**Consultation Response from KC,  
Trees**

**2025/91542 Land at, Highmoor Lane, Hartshead Moor, Cleckheaton, BD19 6LW**

**Erection of 40 dwellings and associated works, including formation of new vehicular access and erection of cricket netting**

**Date Responded: 15/07/2025**

Figure 4.2: Proposed Site Plan at present (Submission of Planning Application)

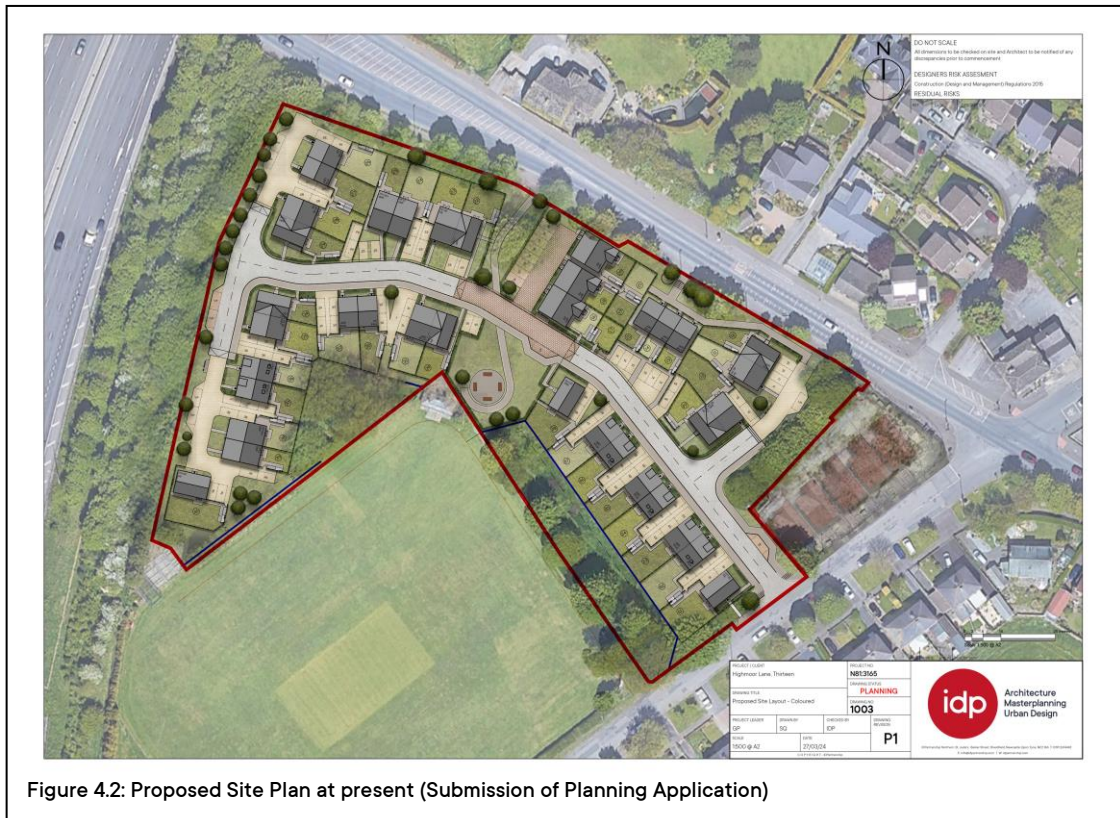
The proximity of plot 01, may indirectly threaten T3, a Cat A protected tree (ref: 03/17/t6). The proposed dwelling is sited immediately north of this mature Sycamore, with a height of 20m. The foreseeable issues of shading and general nuisance may result in pruning, diminishing the amenity value of the tree, or total removal of the tree by future residents. The design should allow for additional space to reduce the foreseeable conflicts between T3 and the dwelling on plot 01. (E.g. move the car parking southward so that the building can be sited northward and increase the distance between the edge of the canopy and the building. This would reduce shading and increase the distance between the building and tree canopy which would relieve anxieties about the tree damaging the home).

There is a footpath proposed within the RPAs of protected trees T23 and T24. Details of a no-dig construction method for the footpath would be required within a submitted AMS.

A footpath is also proposed beneath the canopy, within the RPA of protected tree T91. Additionally, proposed car parking incurs the east side of the RPA and hard standing for the bin-store incurs the RPA to the west. The extent new hardstanding within the RPA cannot exceed 20% of the area, in line with BS5837:2012. The current proposals are not in line with the British Standard and pose an unacceptable risk to the successful retention of protected tree T91.

There are existing hard surfaces which would need to be removed from the RPAs of protected trees T11 to T18 (inclusive), T23, T24, possibly also T45 to T49 (inclusive) and T91. This would need to be carried out sensitively, using hand tools to prevent root damage, under arboricultural supervision. This matter must be addressed within a submitted AMS.

The proposals incur the group TPO 03/17/g2, which protects three poplars identified as T46, T48 and T49 within the JCA tree survey. A no-dig methodology would need to be used to create any new hardstanding within the RPA of T49. However, it is questionable whether future residents of Plot 36 would accept the shade over more than 50% of the rear garden.

58 surveyed items are marked for removal to facilitate the proposals, including thirty Category B trees. Amongst these is T41, which is a significant tree measuring 103cm DBH and 25m in height. This tree is located on the boundary of the site with the adjacent sports ground and is a striking feature in the local landscape. It is expected that this tree should be retained. Perhaps this can be achieved by incorporating it into the POS with additional tree planting to compensate the significant loss to canopy cover proposed on the site.

It is currently not clear why Cat B T60 cannot be retained within the submitted proposals.

Cat B T65 is a Coast Redwood, which can grow to 40m in the UK, is situated immediately south of the home proposed on plot 40. It is likely to be threatened by this proposal due to shading. To reduce the shading, the building could be sited eastward, and the associated parking spaces swapped over the west side. However, it would be preferable to drop Plot 40 and relocate Plots 38/39 within the created space, so that the trees G58, T59, T60, T61, T62, G67 and G66 can be retained. This would preserve the boundary treeline between the site and the cricket ground and the amenity value they afford the locality.

There are offsite trees marked for removal to facilitate the development, which are within third party ownership. These removals include one Cat B tree, T44 and two Cat C items G2 and T29. It is not clear why these removals are required. The Council cannot give consent for the removal of third-party trees. Permission to remove these trees must be received in writing from the owner(s). Furthermore, there are RPA impacts to offsite Cat B tree T97.

No utilities routes were assessed as part of the AIA. Therefore, all utilities must be routed outside of the RPAs of retained trees. Alternatively, the AIA must be amended to include the utilities layout and submitted to the Council.

Development shall not commence until an amended AIA showing the utilities layout and accompanying Arboricultural Method Statement, has been submitted to, and approved in writing by the Local Planning Authority.
